National Infrastructure Planning
Cleve Hill Solar Park

Deadline 6 – Response to Applicant’s Comments on Tom King’s Written Representation in relation to the Outline Construction Traffic Management Plan

Dwg Title: **Articulated vehicle traveling northbound and large car traveling southbound Topographical Survey**

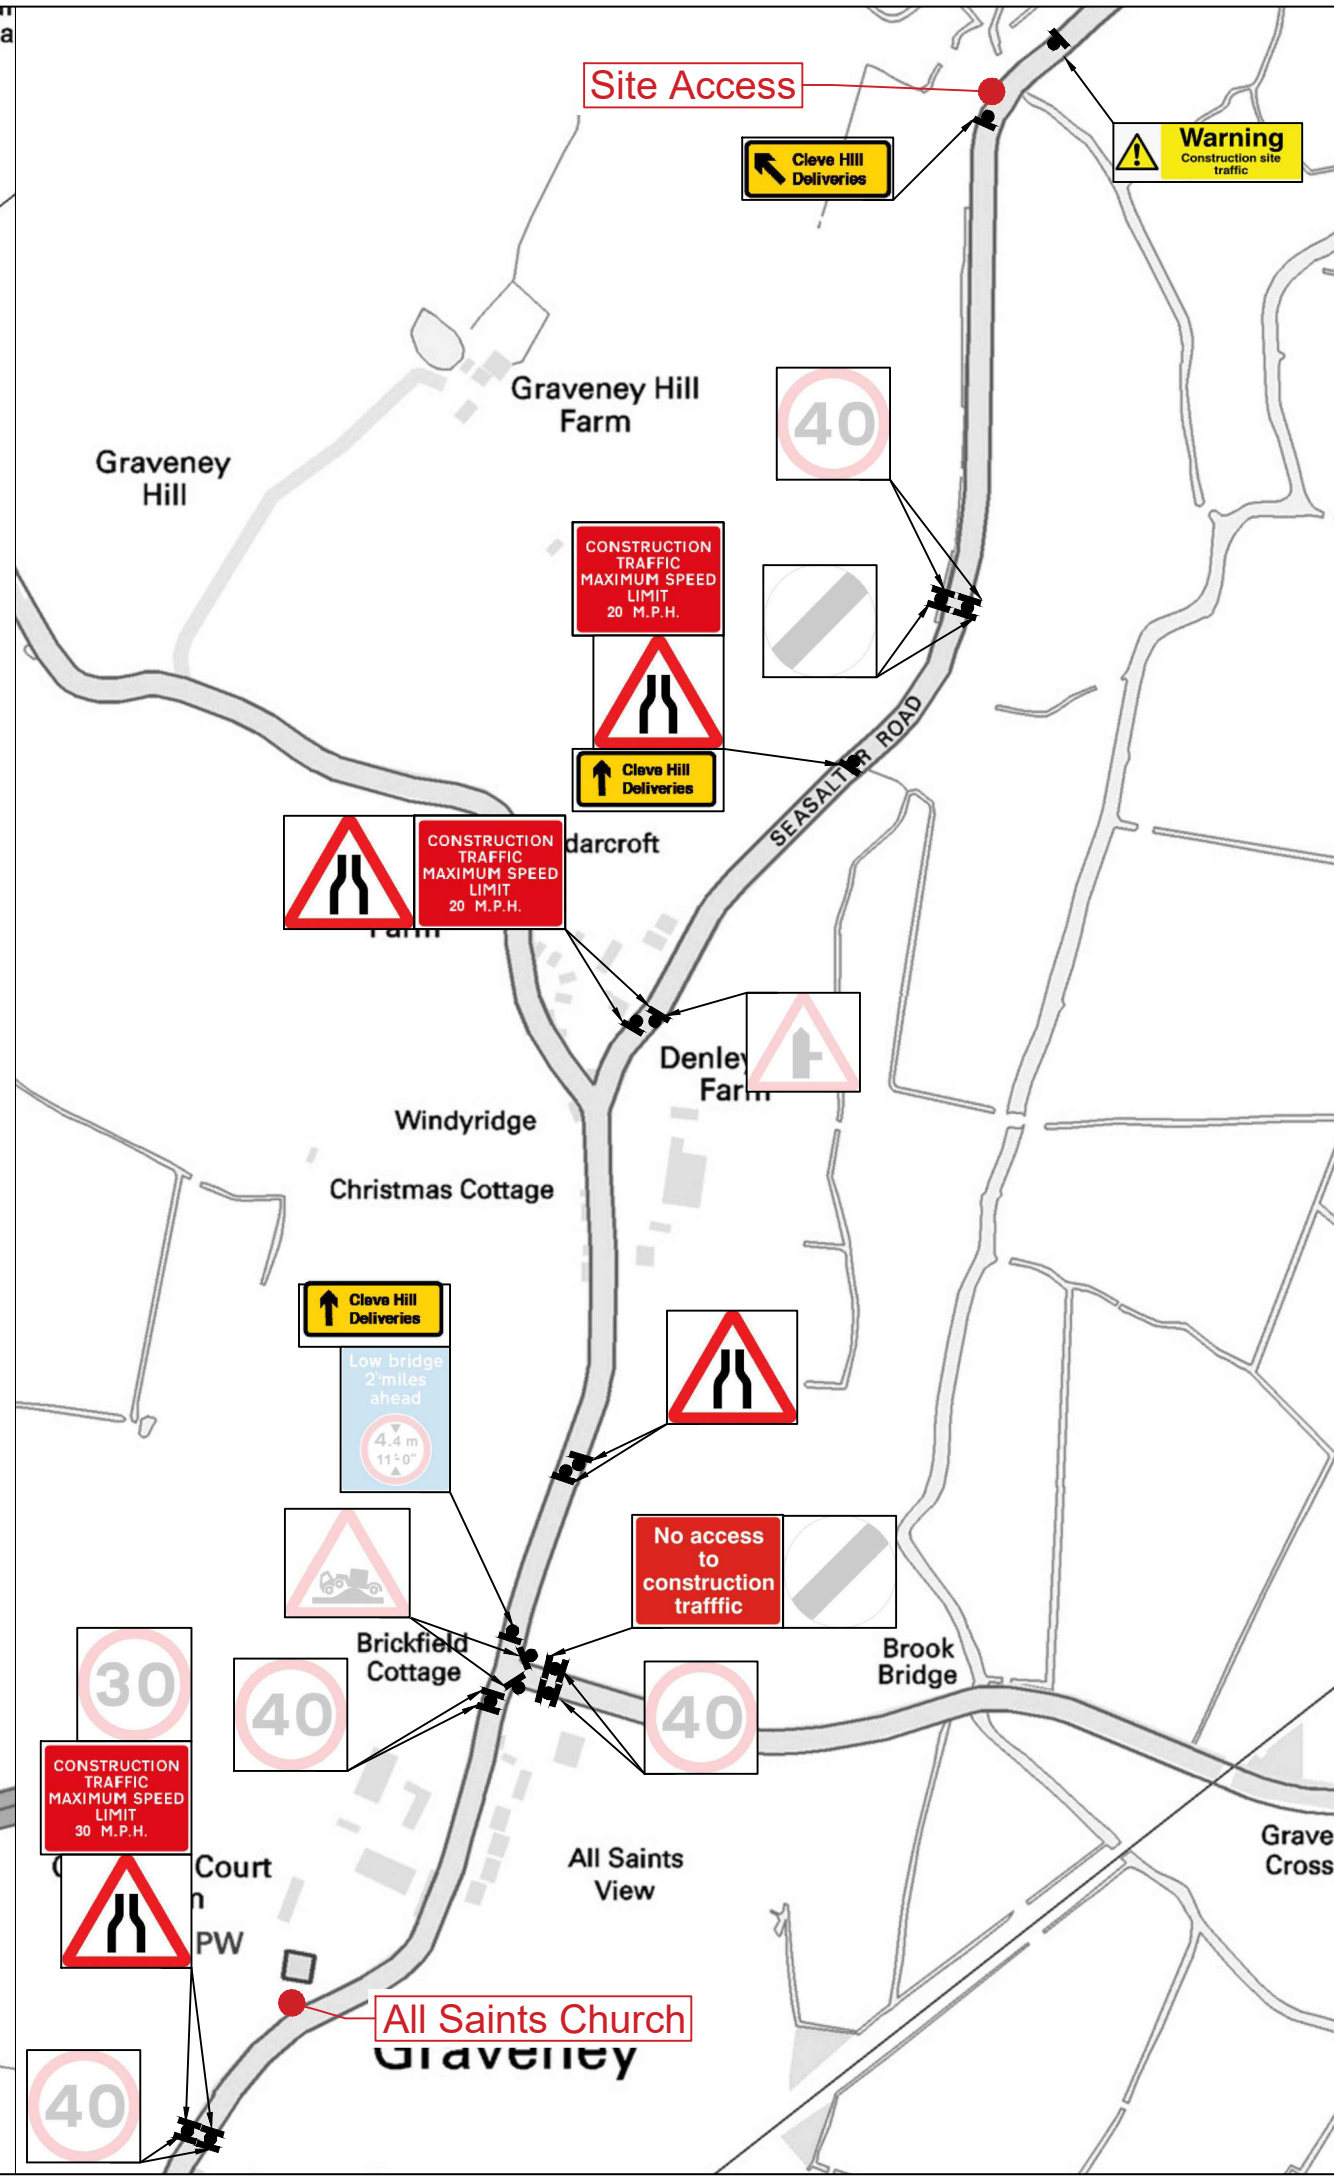
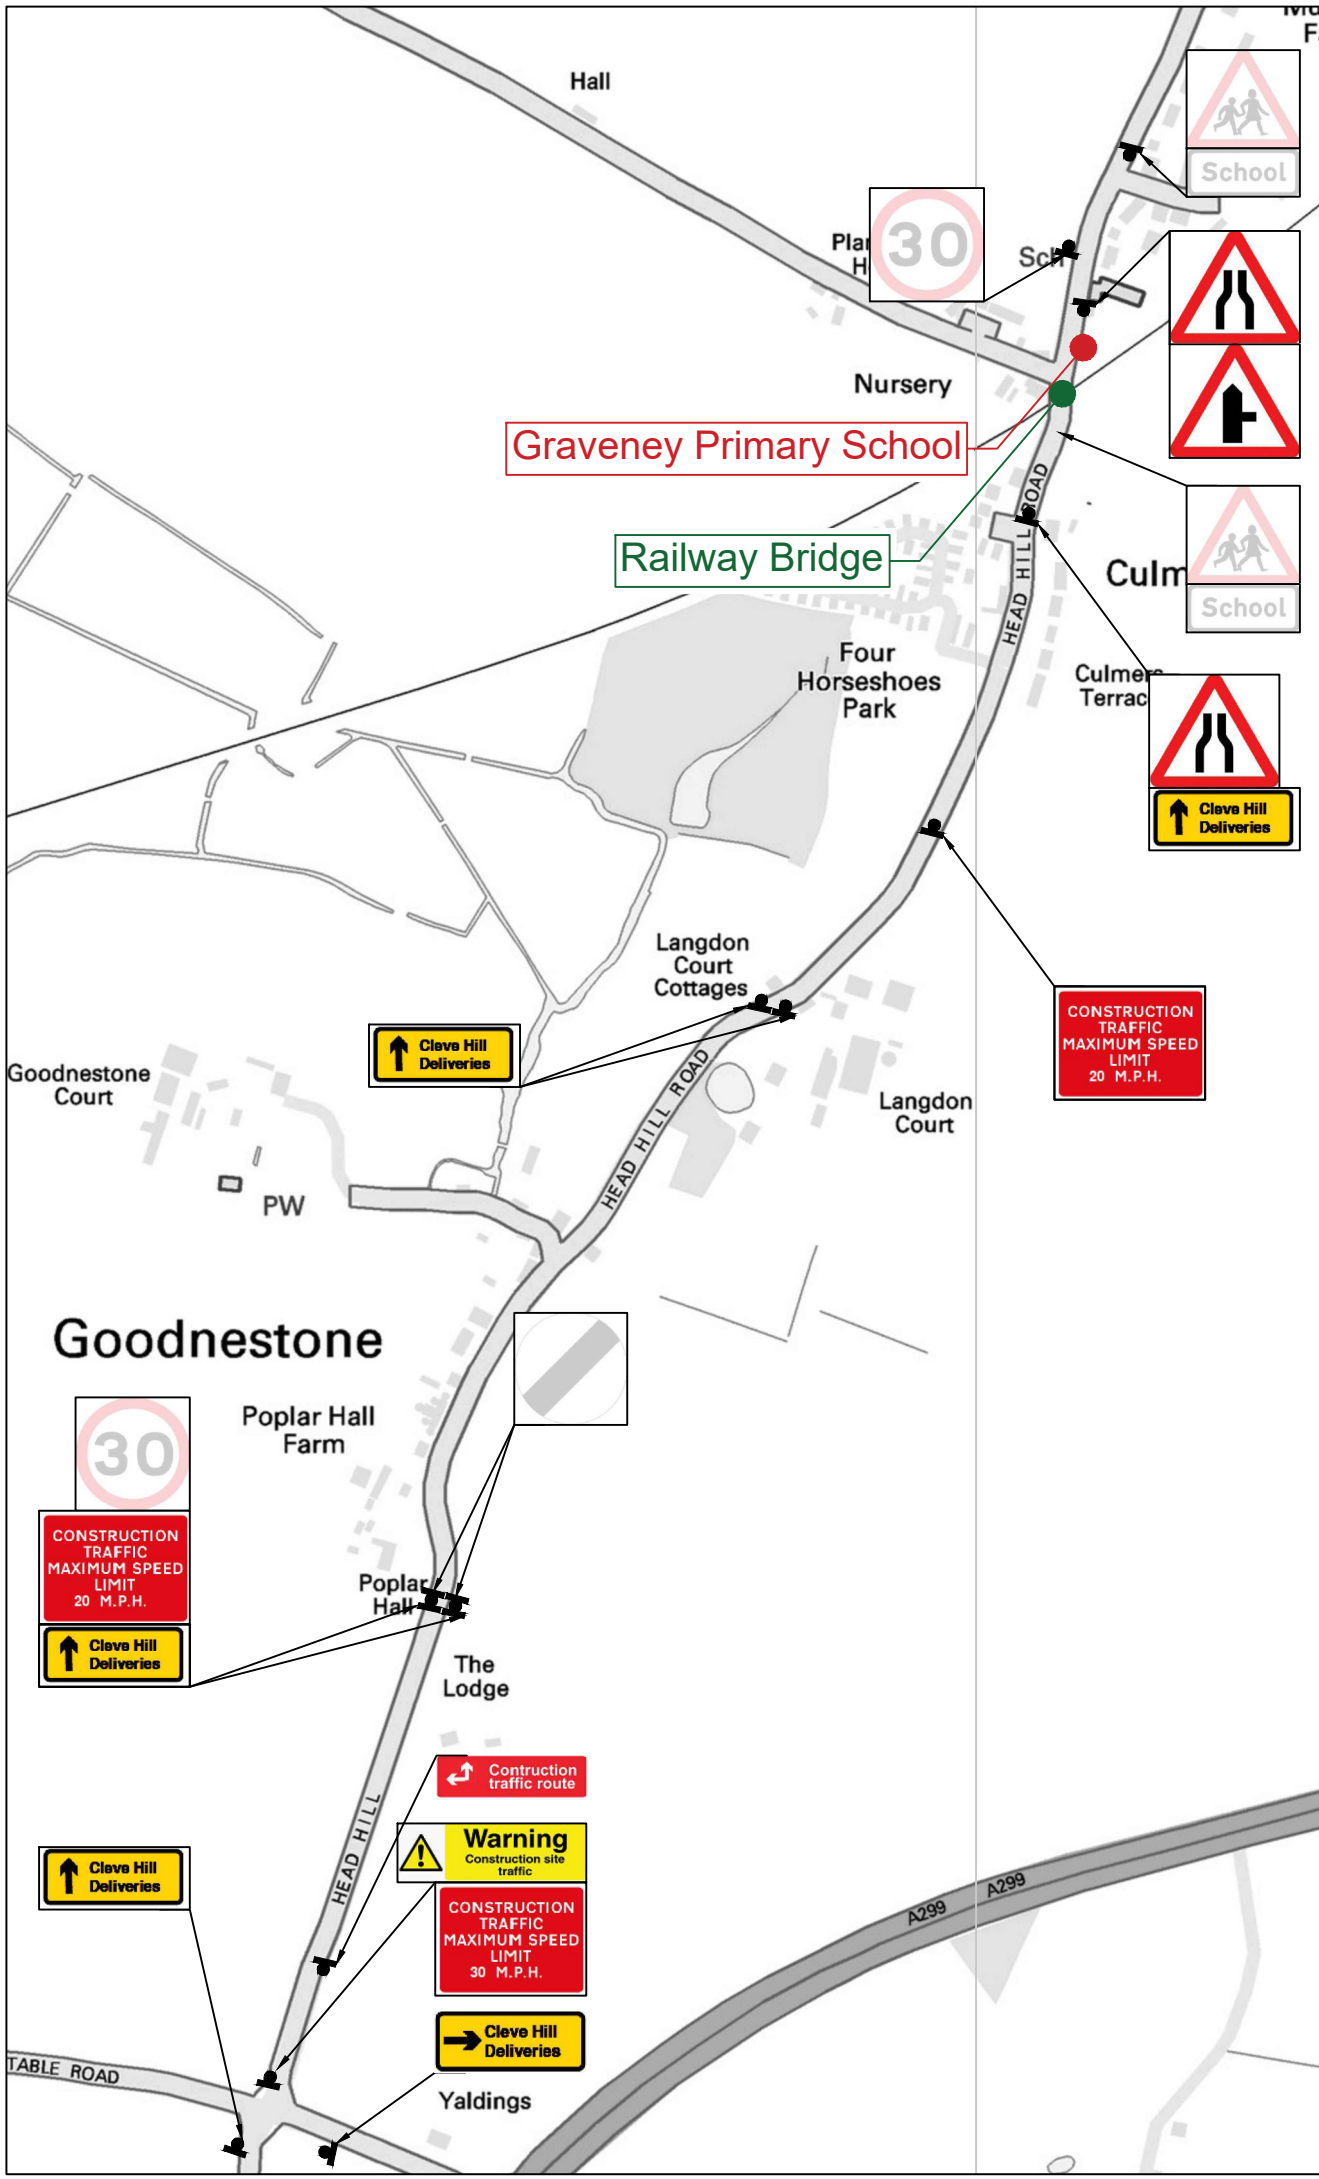
- Width of road:
 - I provided 25 random measurements of the road which contradict the data provided by the Applicant. This issue has not been addressed.

- The Applicant has stated that “At the locations where vehicles are not able to pass each other there is available carriageway ahead to allow a vehicle to wait for another to pass”. This is not true. Currently if there are two vehicles that cannot

pass, one pulls over where possible but quite often this is on to private land (driveways, private layby) or the verges resulting in damage. This is an unacceptable solution for the vast number of additional vehicles that will be present during construction.

- The Applicant has stated that “at these locations good forward visibility was identified”. Again, this is not true. There are a number of areas where it is impossible to see if the road is clear due to the bends and high vegetation. As an example, it is often necessary to follow cyclists for most of Headhill Road because it is impossible to get a clear view of the road ahead.

- In my original submission I asked for the road to be physically assessed as this is the only true way of understanding what it is like and how difficult it is for vehicles to pass. This has still not been done and I have grave concerns about any decisions being made on this being a suitable route for this development based on desk top studies alone.
